ENG-PUDSP21005-R1-GEC.pdf Markup Summary

Add text:
PCD Filing No.:
PUDSP-21-005

Subject: SW - Text Box
Page Index: 1
Date: 5/25/2021 12:11:35 PM
Author: EPC Stormwater - Glenn Reese
Color: ■
Layer:
Space:
Page Label: [1] SHT 1 COVER

WATERBURY FILING NO. 1

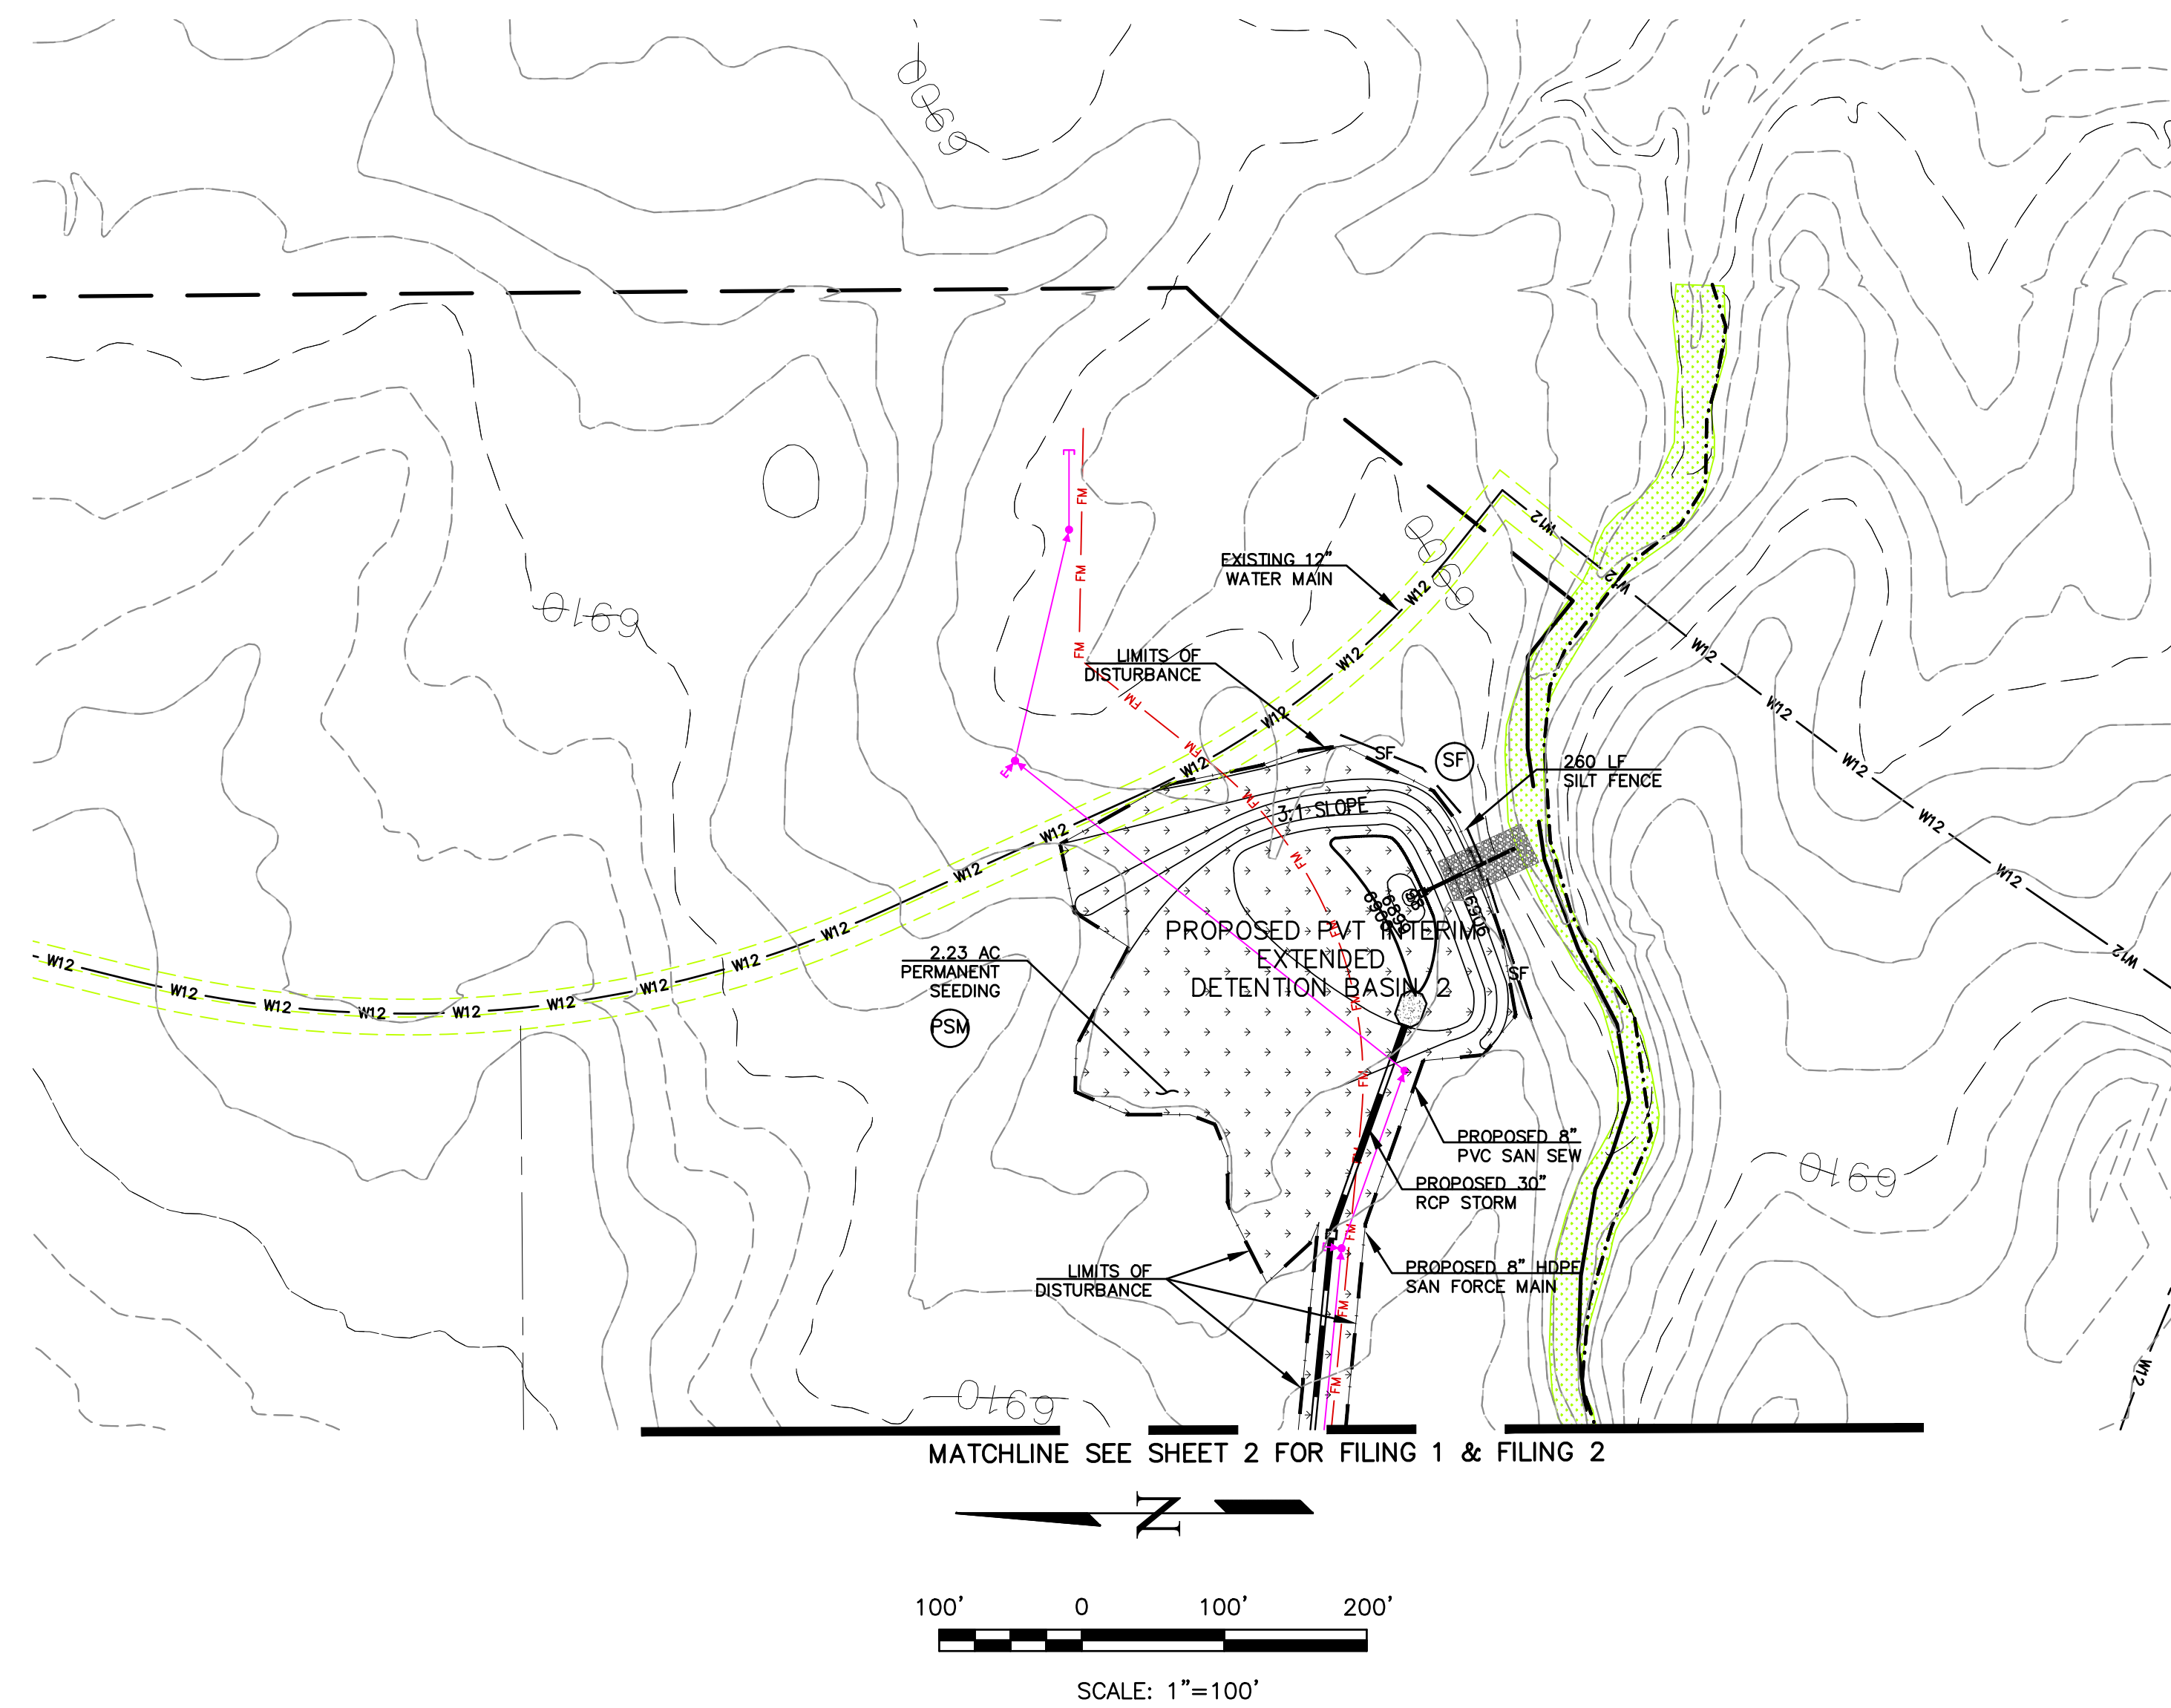
Remove all curb & gutter, storm lines, and inlets from the Pre-development GEC plan. Provide means of conveying the runoff to the temporary sediment basin such as a temporary swale.

For pre-development GEC Plan, revise EDB's to a TSB's.

Provide design details for each TSB, including riser pipe perforation sizing, number of rows, required volume, outlet and spillway locations, and tributary area to the sediment basin.

Show more overlot flow arrows. Currently flows areas are mostly along the street.

Item H and M. If "limits of disturbance" and "construction boundary" are the same, change to "construction boundary/limits of disturbance" or otherwise show as separate linetypes for each on the legend and figure.

Please make lot lines and lot related text a lighter color so topo and BMPs are more visible. You probably don't even need lot lines on the GEC Plan at this overlot grading stage.

Early grading needs to be at least 50 feet from the channel except for necessary channel improvements or crossings.

Early grading won't include storm drains unless a temporary pipe is needed from a TSB -- remove from plans.

Is this stock pond going to be removed? show grading/diversion.

It appears that a diversion is needed to keep upstream flows out of the site.

Is this access needed for early grading? Remove if not.

Revise existing contours so that they are all a dashed linetype.

DESIGNED BY DLF
DRAWN BY QNA
CHECKED BY QNA
H-SCALE NA
V-SCALE N/A
JOB NO. 1715.00
DATE ISSUED 1/15/21
SHEET NO. 4 OF 5

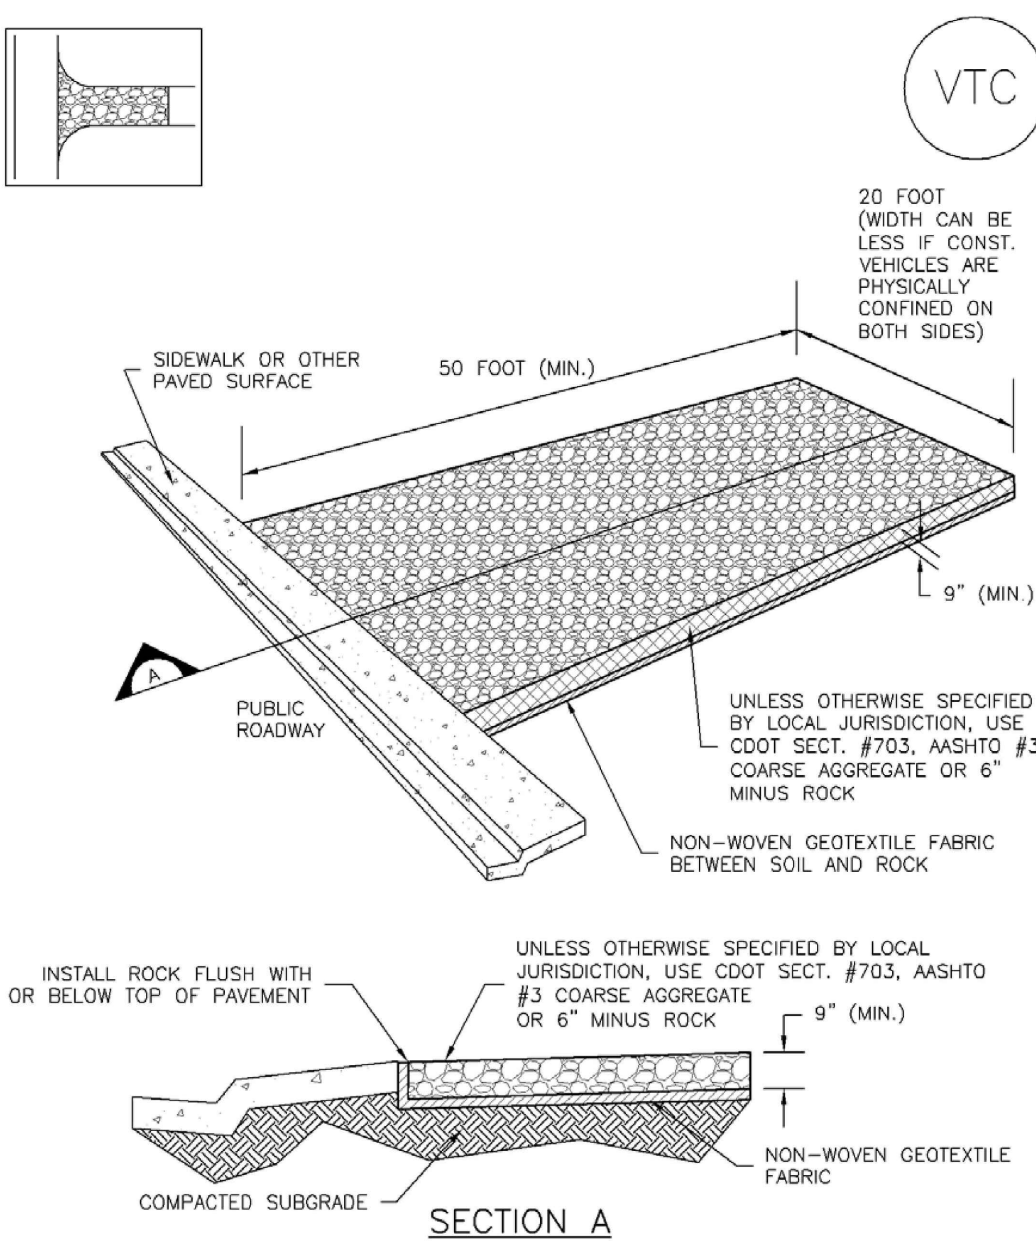
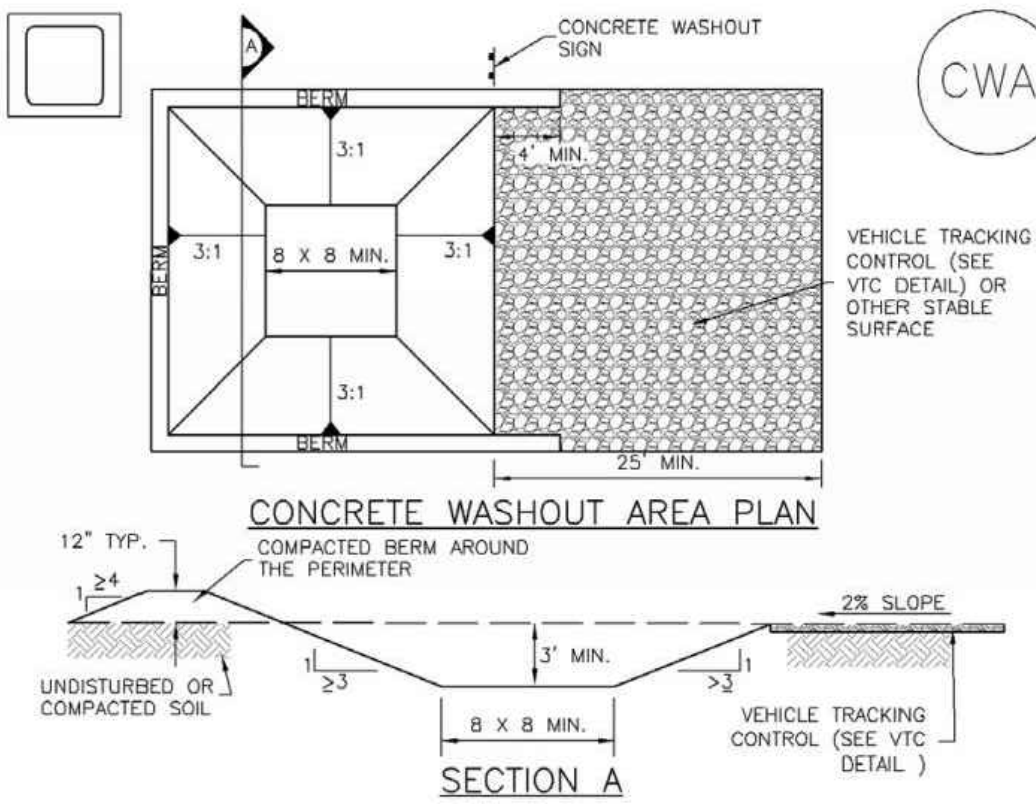
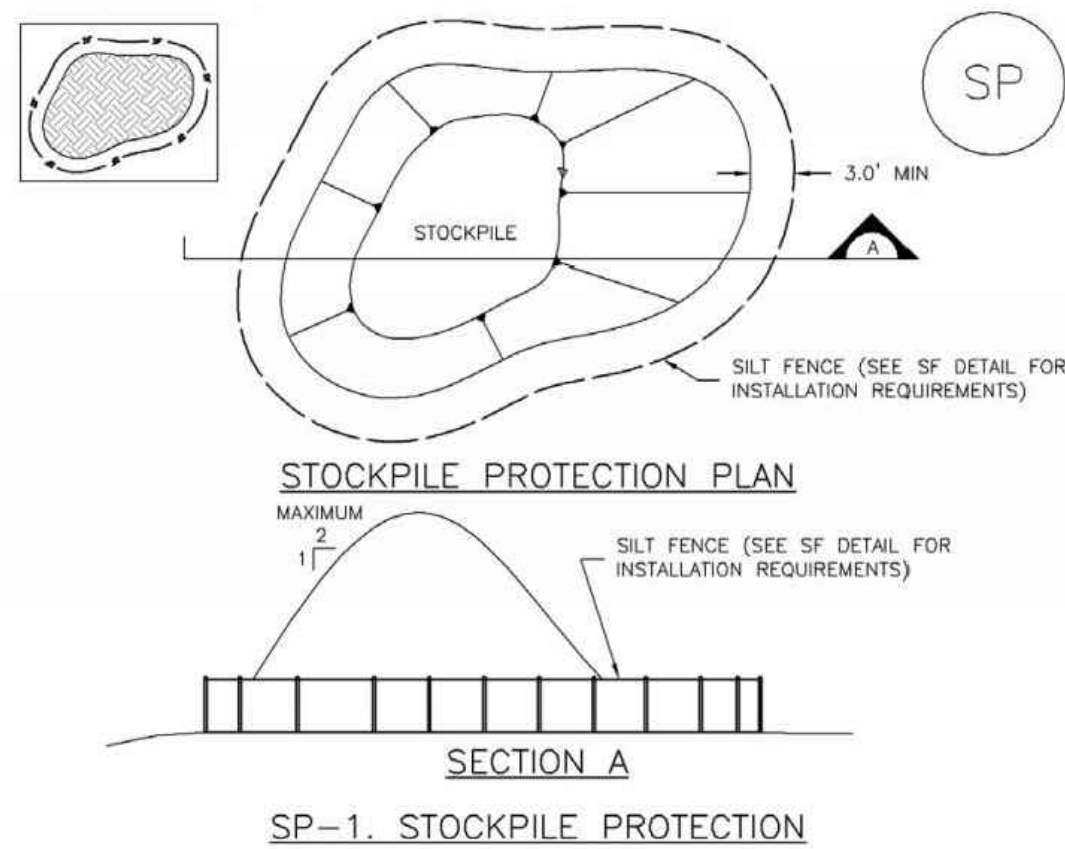
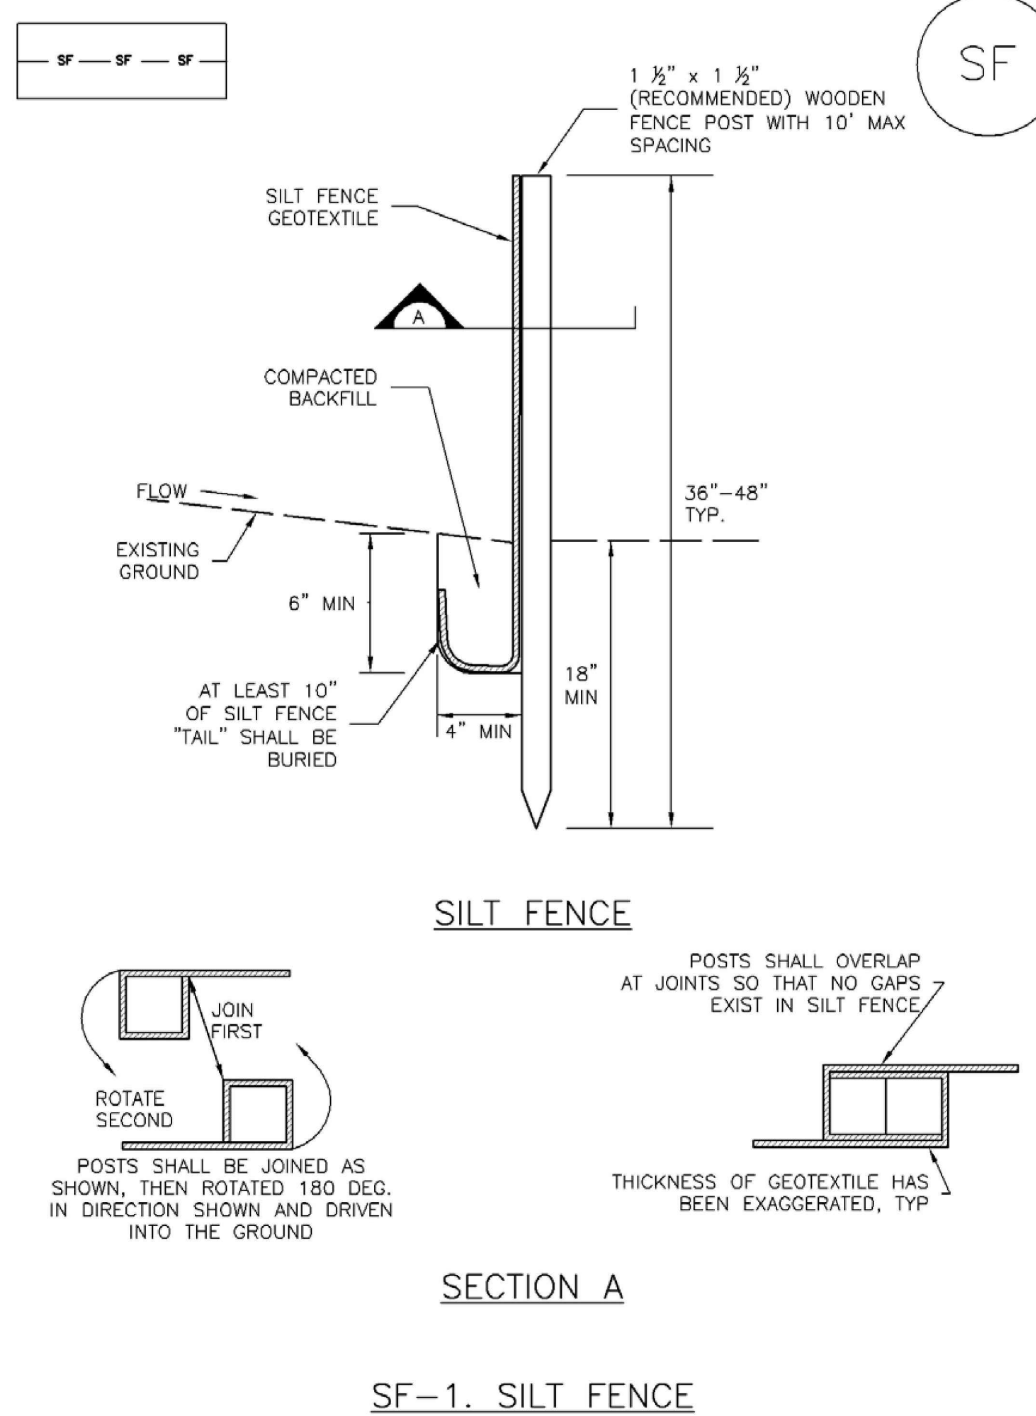
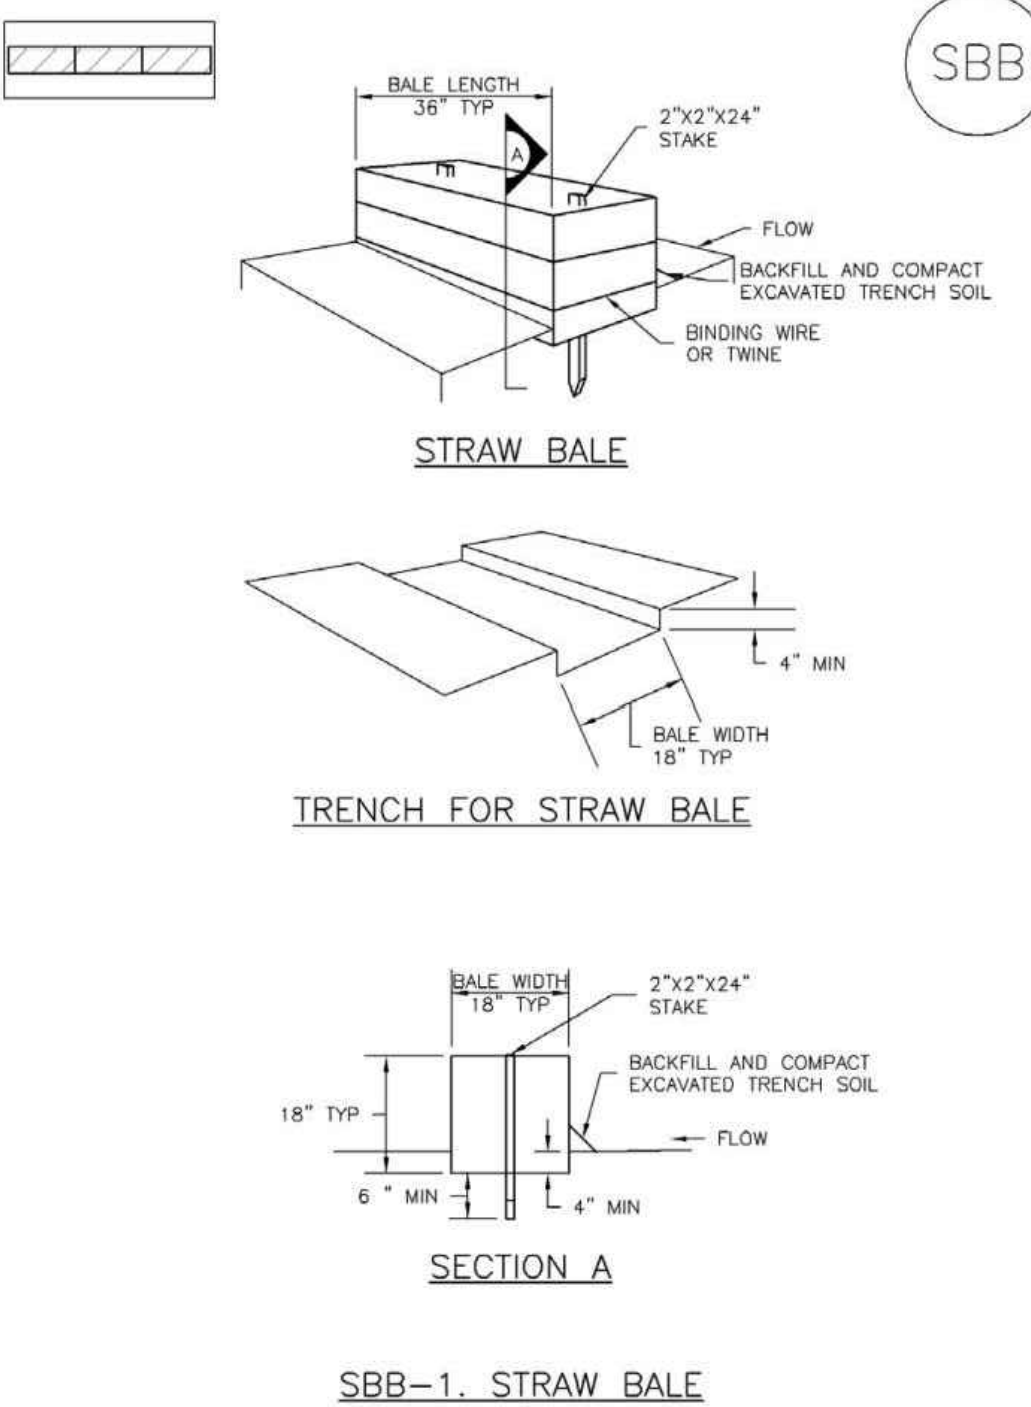
replace with EPC approved VTC detail (VT-1 and VT-2 in DCM Vol. 2, Chap 3.3) or revise to be 75ft min length

Include details for the following BMP's. Examples of acceptable details for each are provided:
